Kirklees Flood Management & Drainage (Lead Local Flood Authority) – Statutory Consultation

Consultation on Application Number: 2018/91661

Address: Outline permission for residential development and facilitating engineering operations and full planning permission for access and spine road

Proposal: Land at Walkey Terrace and Brunswick Street, Heckmondwike

**INDICATIVE PROPOSED SITE LAYOUT**

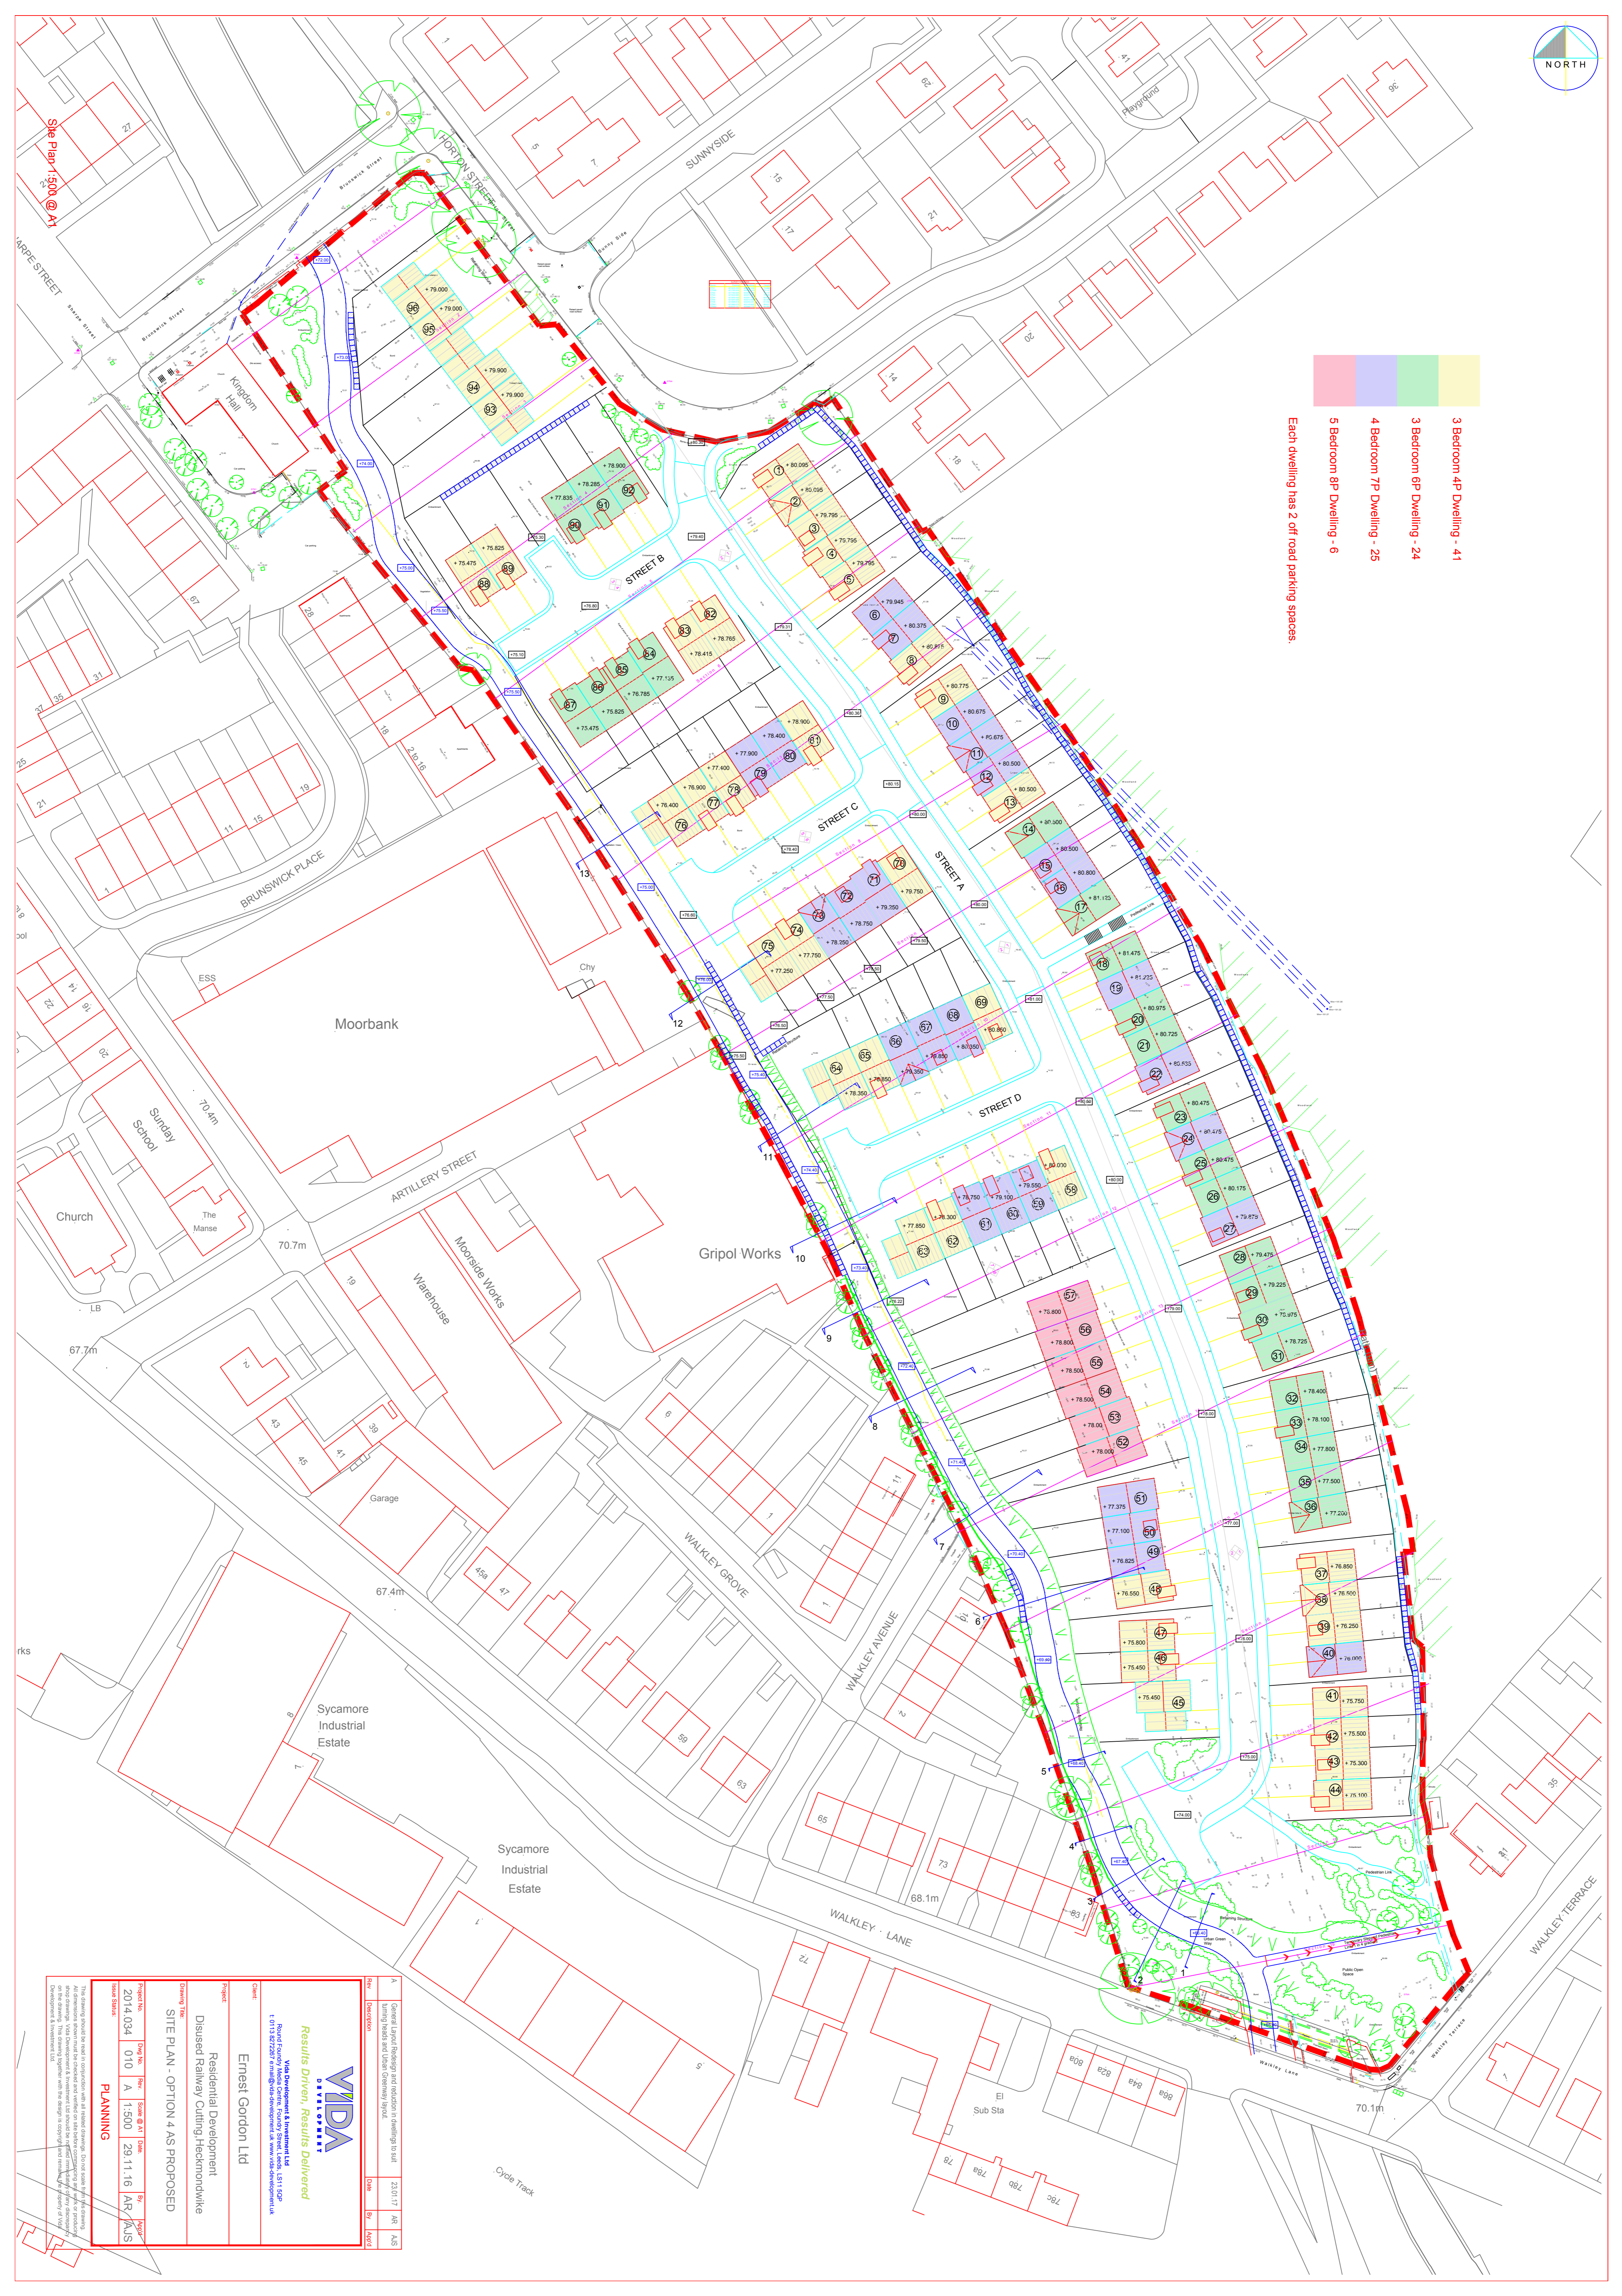
An estimate of storage requirements and how and where these will be placed in the indicative layout plans is required, remembering that structures 1500mm or greater under the highway may preclude adoption agreements being signed with the Council.
